WEST SUSSEX COUNTY COUNCIL CONSULTATION

TO:	Arun District Council FAO: Anita Gardner
FROM:	WSCC - Highways Authority
DATE:	9 December 2021
LOCATION:	Land at Wren Cottage, Horsemere Green Lane, Climping, BN17 5QZ
SUBJECT:	CM/70/21/PL Subdivision of the plot and construction of 3 detached bungalows with associated parking, access and landscaping (resubmission of CM/17/21/PL). This application is in CIL Zone 3 and is CIL Liable as new dwellings.
DATE OF SITE VISIT:	N/A
RECOMMENDATION:	Advice
S106 CONTRIBUTION TOTAL:	N/A

Proposed Site Plan

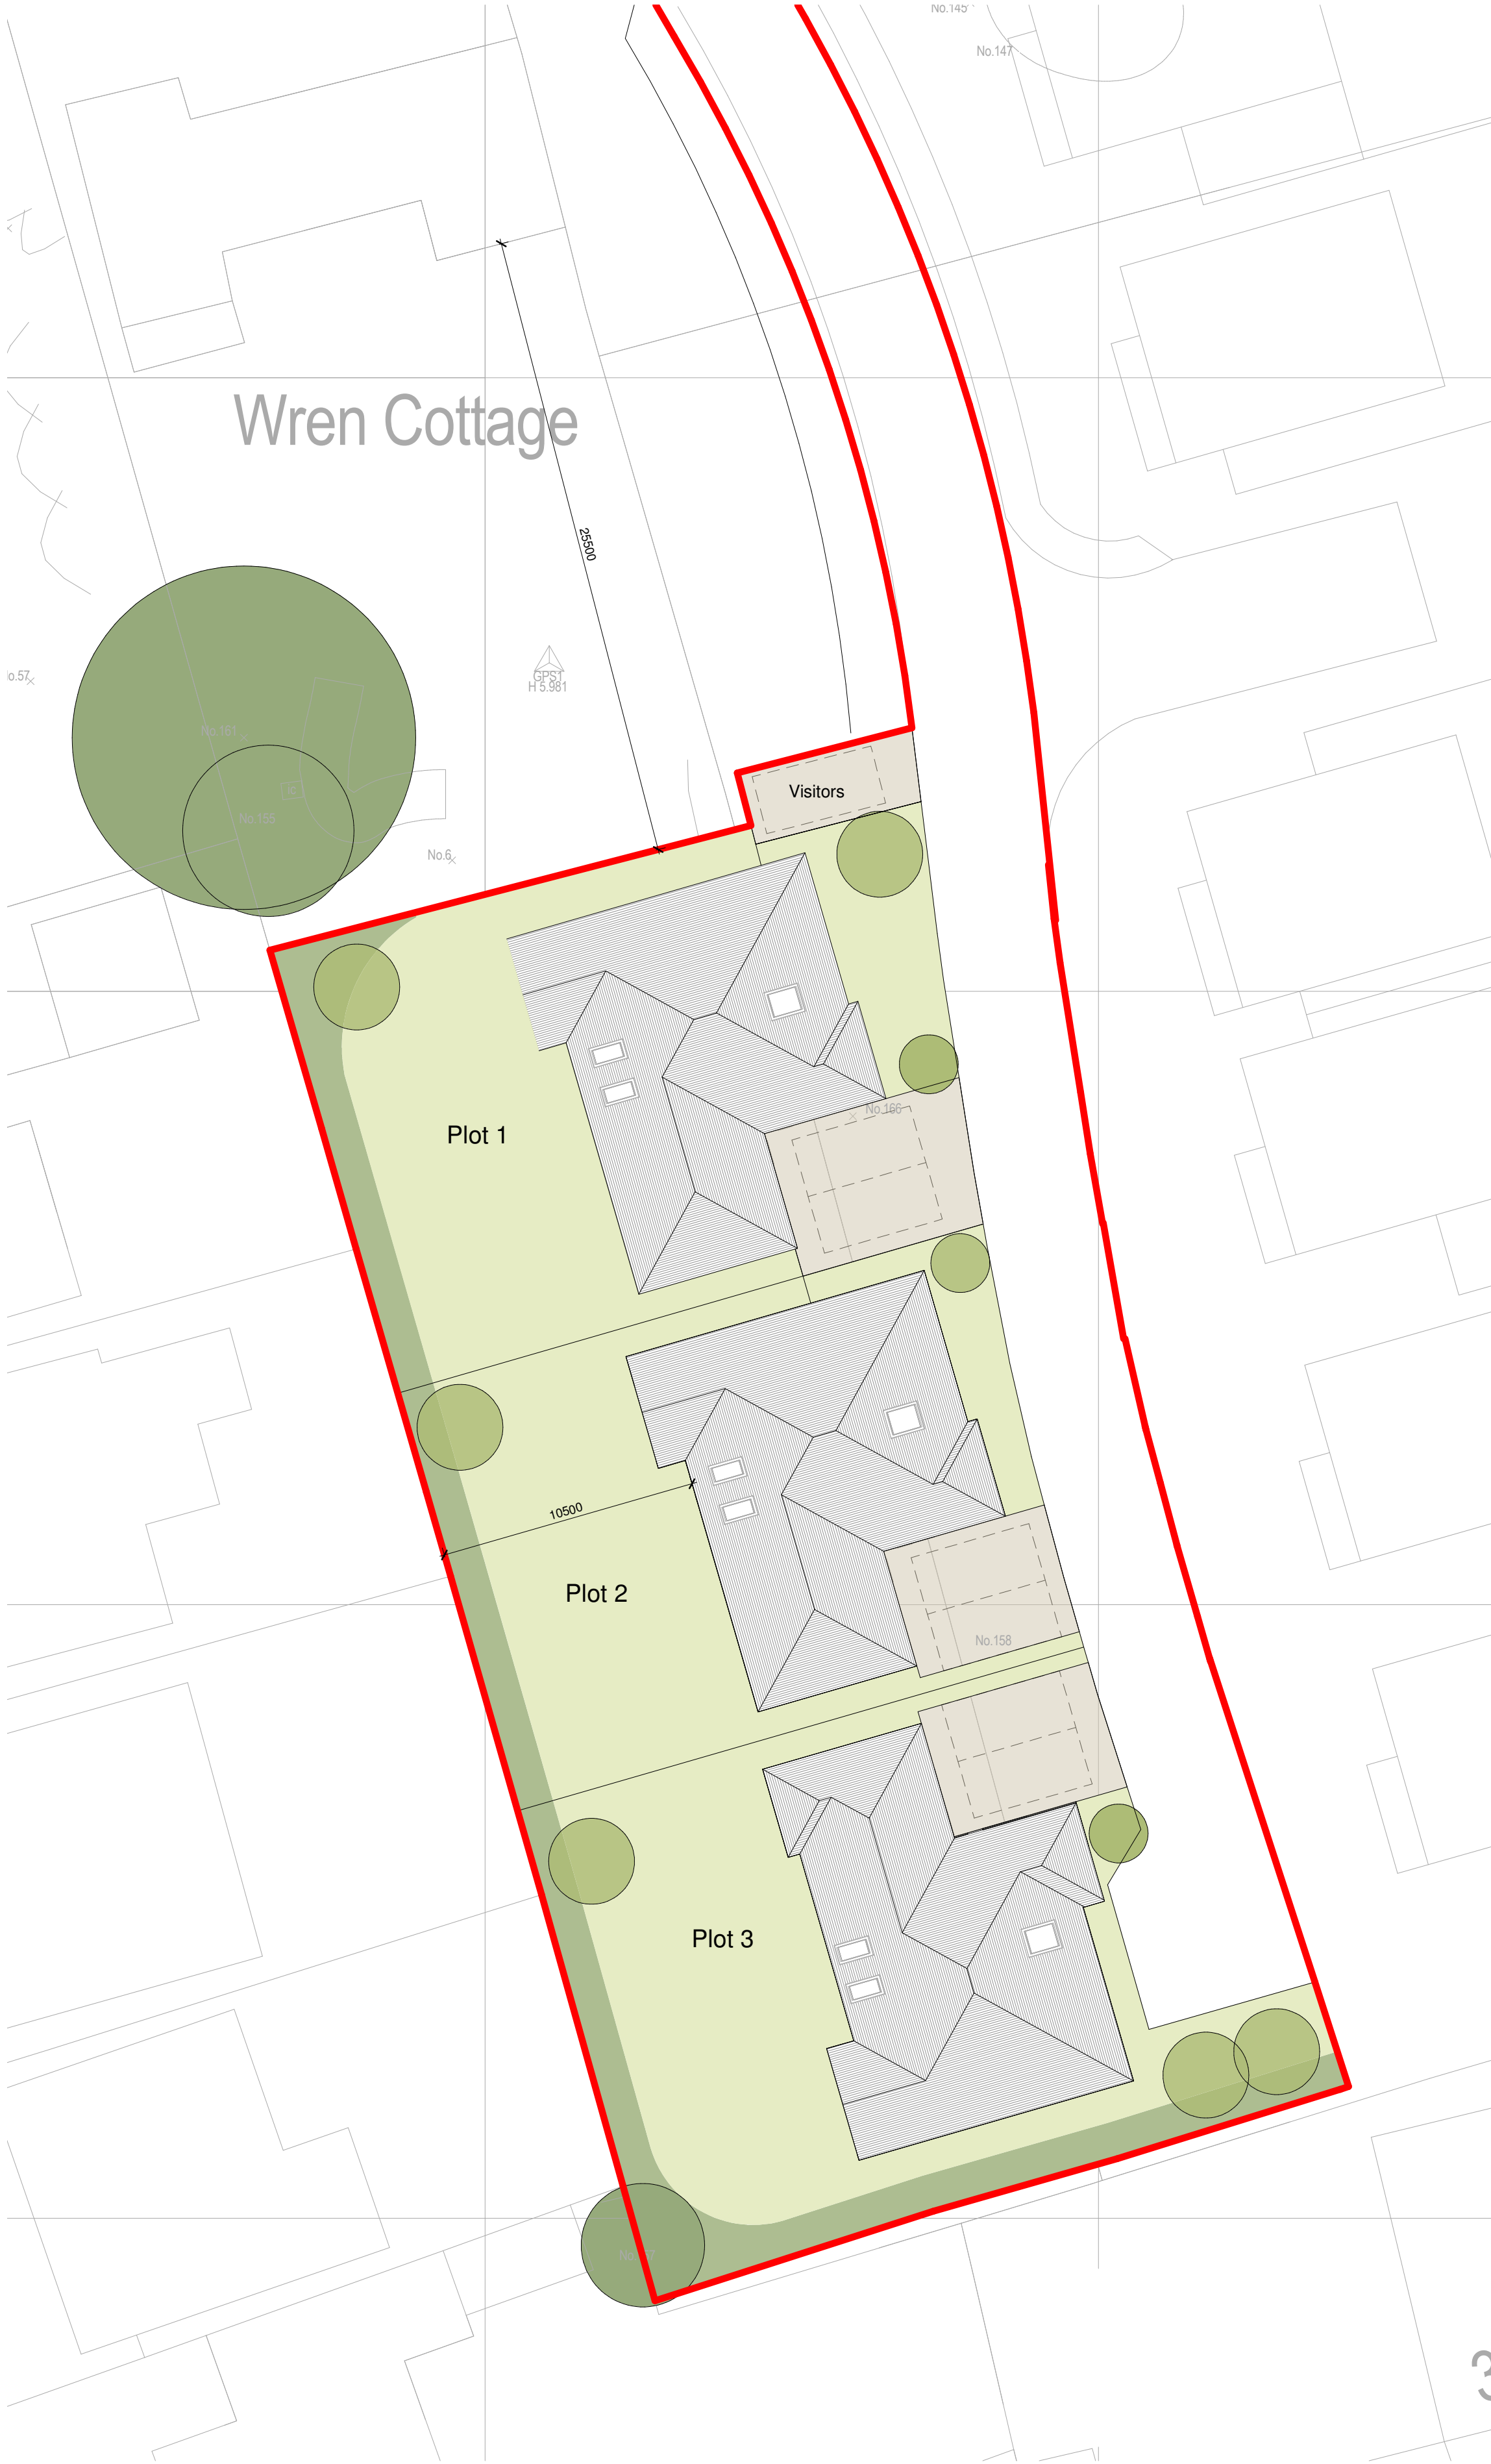
From inspection of the plans, the applicant proposes to utilise the vehicular access approved under application CM/21/19/PL. There are no apparent visibility issues with the proposed access point on Horsemere Green Lane. The LHA does not anticipate that the proposed development would give rise to a significant material intensification of movements to or from the site.

The applicant proposes ten car parking spaces for this development, with each plot being provided with a single-bay garage and two-bay driveway. One visitor parking space is also proposed. Under Arun Parking Standards, the LHA would anticipate a parking requirement of six parking spaces for this development. Therefore, the LHA is satisfied with the level of proposed parking provision. From inspection of the plans, the proposed garages and parking bays are suitably sized. Cars can utilise the private access drive to turn and exit onto the maintained highway in a forward gear.

In the interests of sustainability and as result of the Government's 'Road to Zero' strategy for at least 50% of new car sales to be ultra-low emission by 2030, electric vehicle (EV) charging points should be provided for all new homes. The applicant is advised that for dwellings with an off-street parking provision, 100% of parking spaces should be provided with active EV parking spaces in accordance with the Arun Parking Standards.

Regarding cycle parking, the garages are suitably sized to be considered for secure cycle parking provision. The inclusion of secure and covered cycle parking provision helps promote the use of sustainable transport methods.

No part of the development shall be first occupied until the car parking has been constructed in accordance with the approved site plan. These spaces shall thereafter be retained at all times for their designated purpose.

No part of the development shall be first occupied until covered and secure cycle parking spaces have been provided in accordance with plans and details to be submitted to and approved by the Local Planning Authority.

No part of the development shall be first occupied until the electric vehicle charging space(s) have been provided in accordance with plans and details to be submitted to and approved by the Local Planning Authority.
